## Nicholas Hall - Marstel Bulk Liquid Fuel Storage Facility EA 08\_0130

**From:** Valentina Misevska  
**To:** Nicholas Hall  
**Date:** 12/23/2011 12:15 PM  
**Subject:** Marstel Bulk Liquid Fuel Storage Facility EA 08\_0130

Please see HDC's comments on the Marstel Environmental Assessment (EA).

Figure 9: Construction and Operational Access Roads

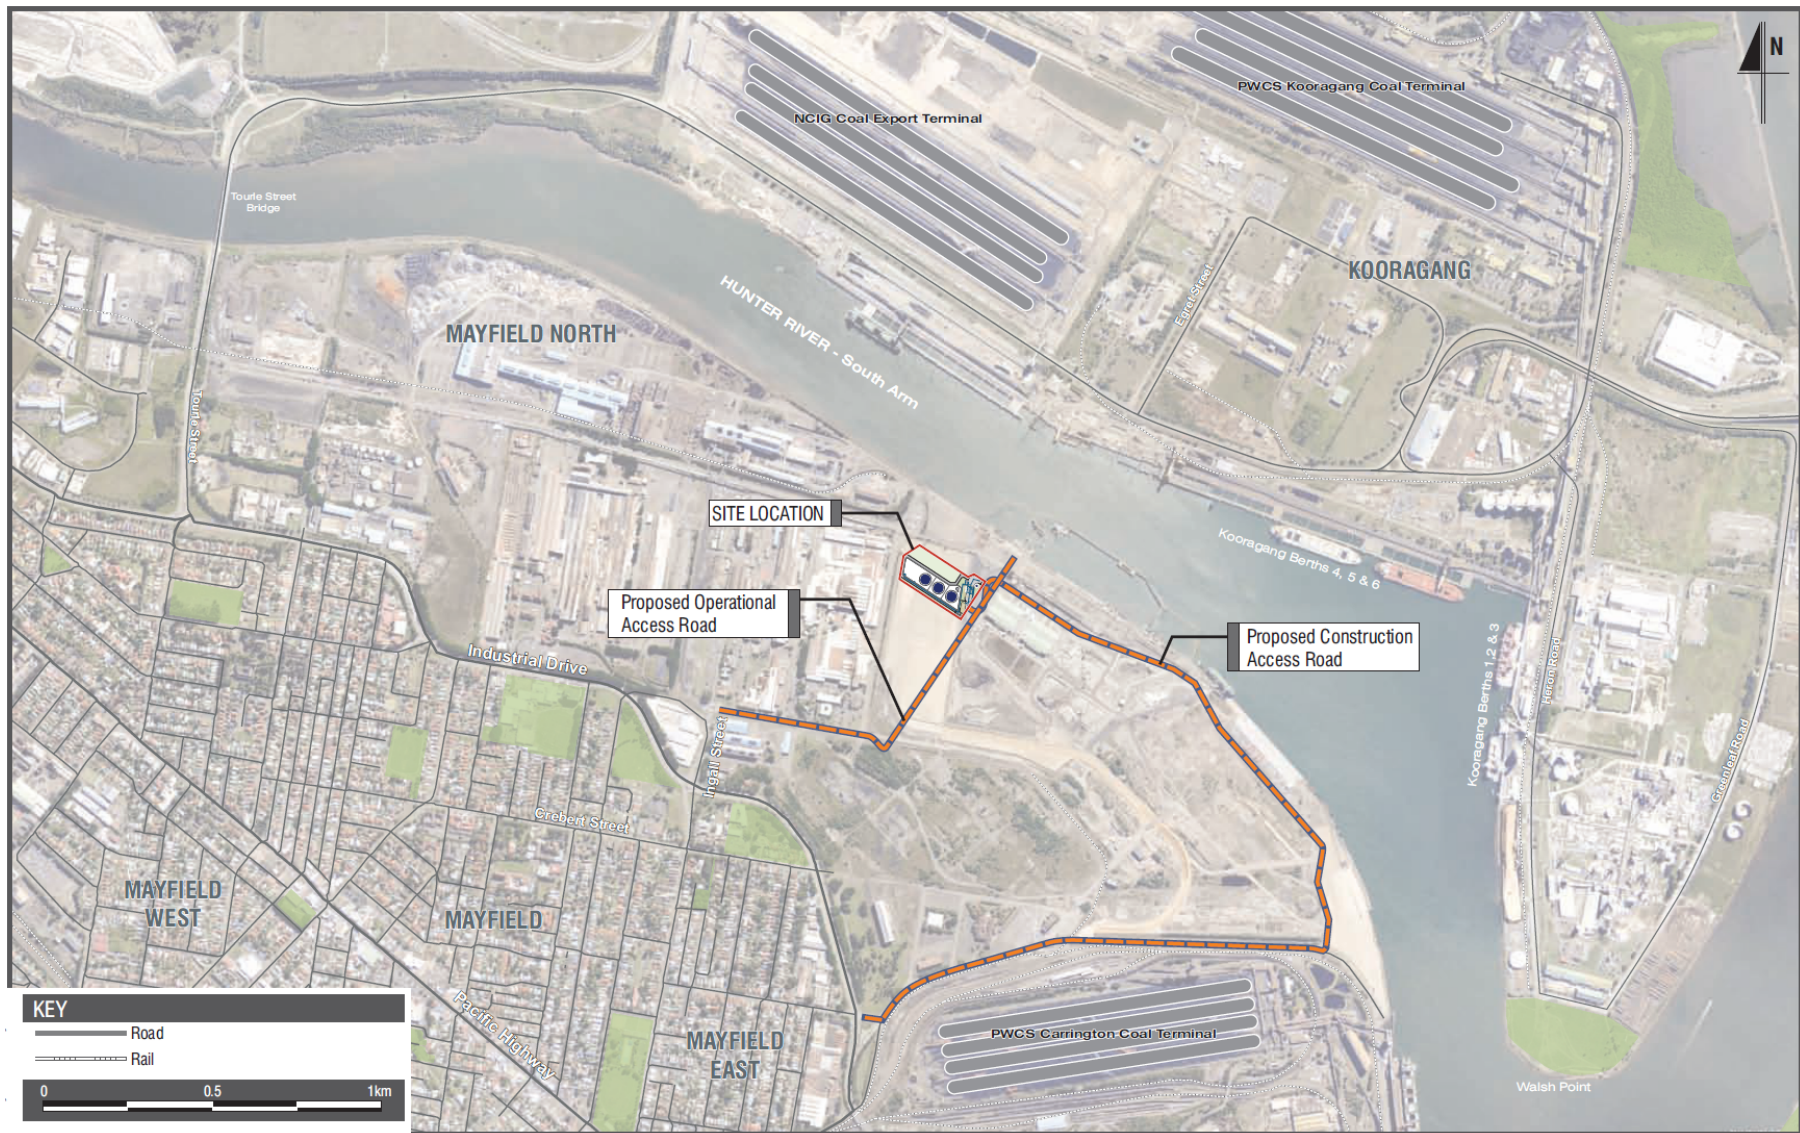
The EA states that there is a contractual relationship between Marstel and NPC under which NPC is to provide access and services to the project site boundary. During the operational phase NPC will provide a permanent road and services access from Ingall Street and Steelworks Rd (Section 3.3 and 3.4). The EA also states that certain access and service connections are to be provided as part of the initial stage of the Intertrade Industrial Park development and if they are not available in a time frame that meets the requirements of the Mastel proposal there will need to be further detailed investigations on alternative options (section 3.5.5).

HDC notes that currently, NPC does not own or have any rights to carry out such works to the extent that they are required on the Intertrade Industrial Park lands. While it is expected that Buildev Intertrade Consortium Pty Ltd, as the developer of those lands, will construct roads and service connections along Steelworks Rd at some time during Marstel's operational phase, the timing and design of such roads and service connections has not been finalised. They are currently expected in the second stage of development, not the initial one, and in the case that such roads and service connections are not provided within Marstel's time frames or at all, alternative arrangements would need to be considered.
